**NARAMA WEST MODIFICATION**

# **RESPONSE TO SUBMISSIONS**

**Xstrata Coal Pty Limited**

June 2013

Figure 1 – PPV vs Distance

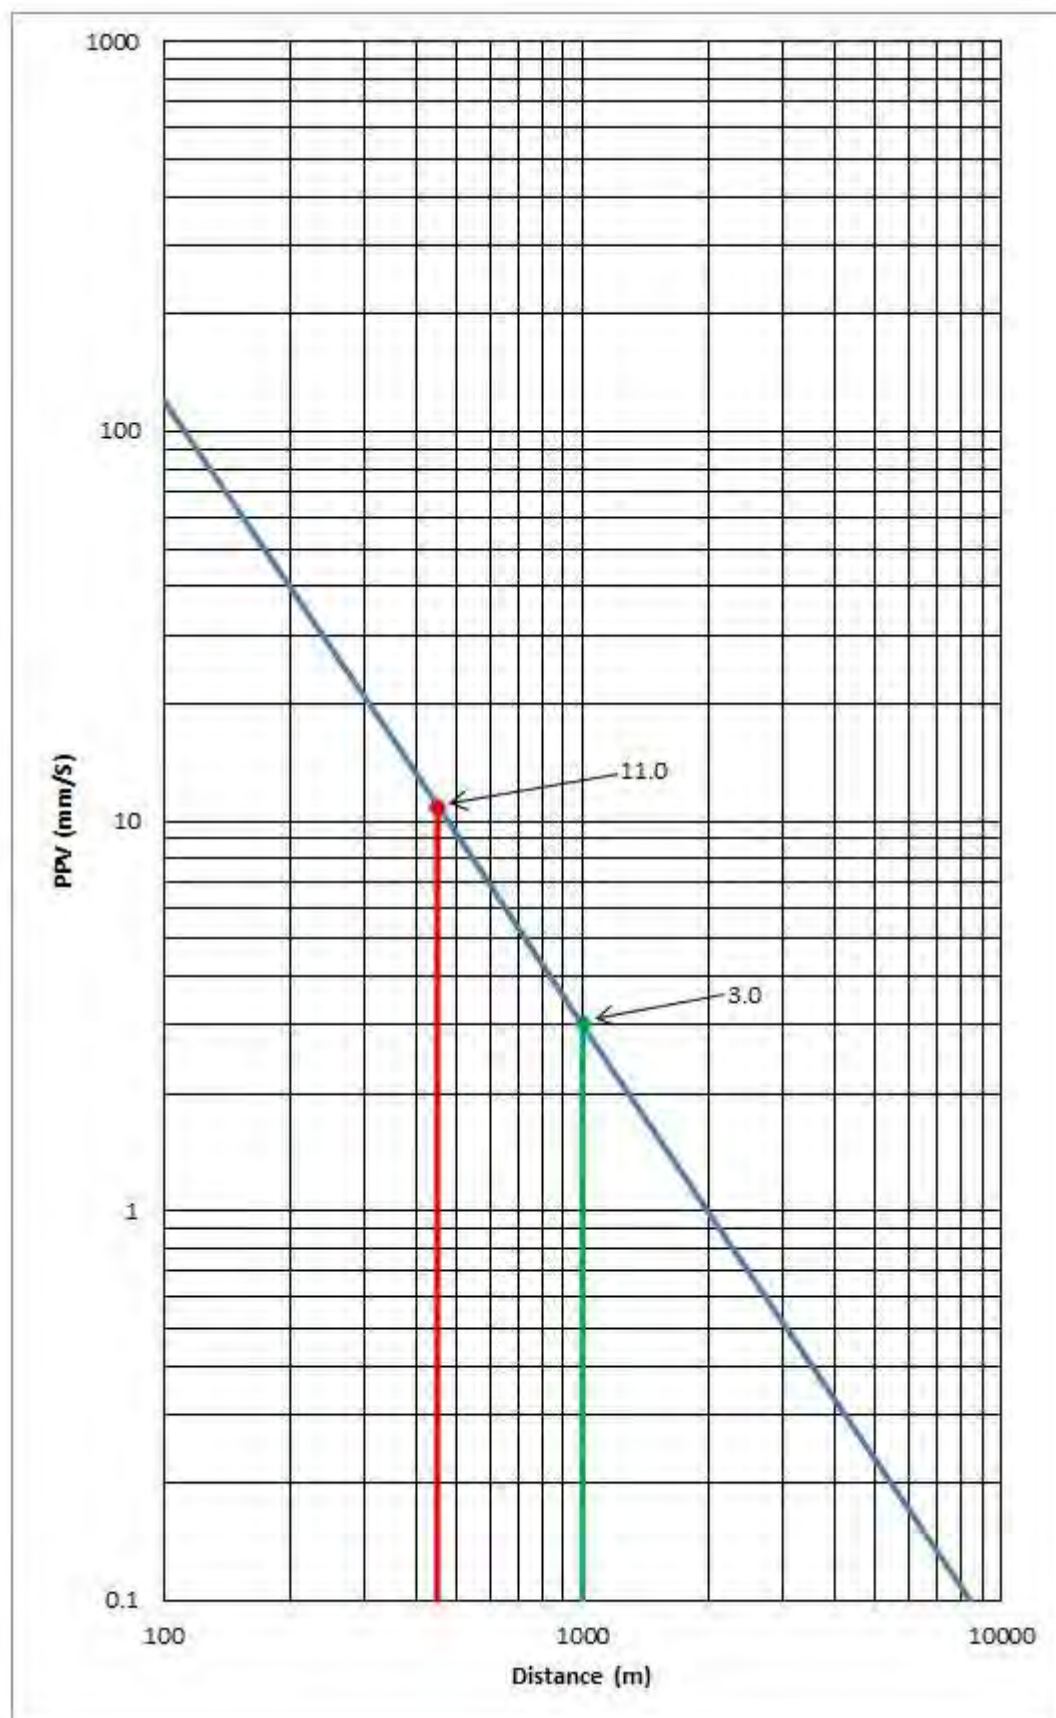
- Editorial matter. OEH refers to Figure 1 of the letter from Terrock Consulting Engineers (dated 19 February 2013). Further information is required by the proponent to clarify the source of the data presented in this figure.*

A meeting was held with OEH on 24 May 2013 to discuss the key issues raised in their submission pertaining to the EA. From this meeting, it was requested that Xstrata Coal review and consider the additional literature that had been identified and provided by OEH. Accordingly, Terrock Consulting Engineers (Terrock) has completed a review of the additional literature articles. A list of the reference articles reviewed and the findings of this review are provided in **Appendix B**. In summary, Terrock concluded that the additional reference documents do not provide any new or relevant information that can be used for the assessment and as such does not alter the conclusions of Appendix G as provided in the EA.

Further to the literature review, Terrock has prepared a supplementary report, which outlines the scientific approach that was adopted in Appendix G of the EA. It also provides additional justification for the proposed staged approach to incrementally increase the blast vibration criteria for Aboriginal grinding groove site REA 86 (REA 86) and addresses potential cumulative effects (see **Appendix C**). This document was provided to OEH on 4 June 2013 to inform their decision making process.

Figure 5: Proposed Amendment to Project Boundary

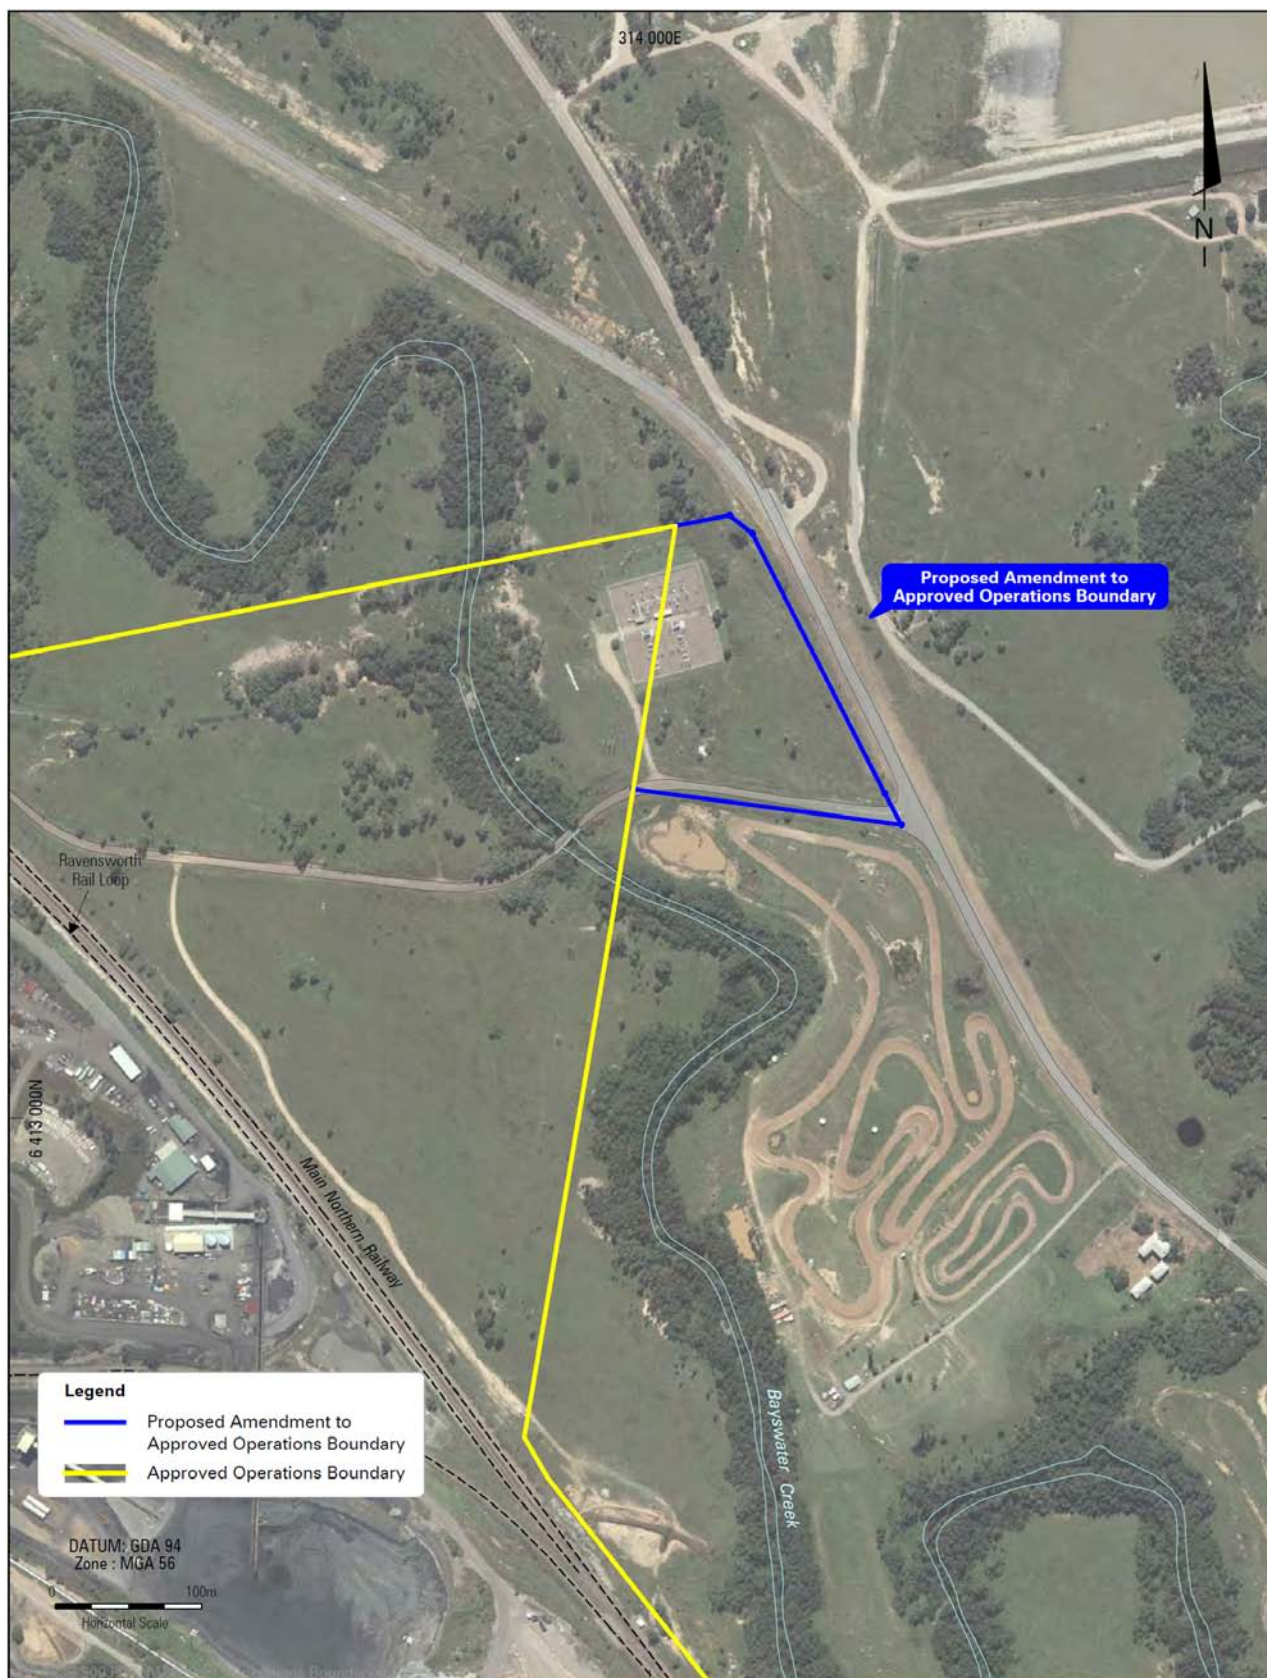
OEH refers to the discussions between Ravensworth Operations and OEH on 27 July and 27 August 2012 concerning the Newdell substation augmentation works program and the location of the approved project boundary. It is noted that Aboriginal cultural heritage values are located in this area and the immediate surrounds. This includes Aboriginal sites 'LID6' (site # 37-3-0448) and 'LID4' (site # 37-3-0451) and associated PADs. It was understood that there was a possibility that the substation augmentation works program had the potential to disturb Aboriginal objects and this disturbance may occur outside of the currently approved 'project disturbance area' in an area to be protected and monitored only.

OEH also understands that the proponent committed to investigating this matter further in accordance with the approved ACHMP, in consultation with the Aboriginal community following advice from the DP&I (in letter dated 21 August 2012) and prior to any augmentation works being undertaken. However, the current modification proposal has not included any additional details of the investigations undertaken or any of the results obtained in support of this proposal. It is therefore strongly recommended that the proponent provides additional details documenting the Aboriginal cultural heritage values associated with this additional area in support of the proposed development modification. These should include:

- Details of any additional Aboriginal cultural heritage investigations undertaken within the proposed amendment to the approved operations boundary
- Details of any Aboriginal sites and/or PADs associated with this area
- In the event that any additional development activities likely to occur in this area have the potential to, or, are likely to impact or harm Aboriginal objects, detailed management strategies development in consultation with the registered Aboriginal parties for this project.

OEH is therefore not in a position to support the proposed amendment to the approved operations boundary until the above matters are addressed by the proponent.

The proposed amendment to the approved operations boundary is an administrative amendment only and does not seek approval for any works or disturbance in this area. The Newdell substation is already constructed and in operation and no changes to this, as currently approved, is proposed. The requirement to amend the approved operations boundary was requested by DP&I given that the boundary currently runs through the centre of the substation. The proposed amended operations boundary encompasses the substation entirely by following the cadastral boundary on which the substation is located.

To reiterate the findings in the EA, this amendment to the approved operations boundary will have no operational or environmental consequence, including no impacts to items of Aboriginal heritage. As such, no additional Aboriginal cultural heritage investigations are deemed necessary for this area. This matter was clarified with Diane Crossdale, Manager Planning and Aboriginal Heritage for OEH, in a meeting on 24 May 2013.
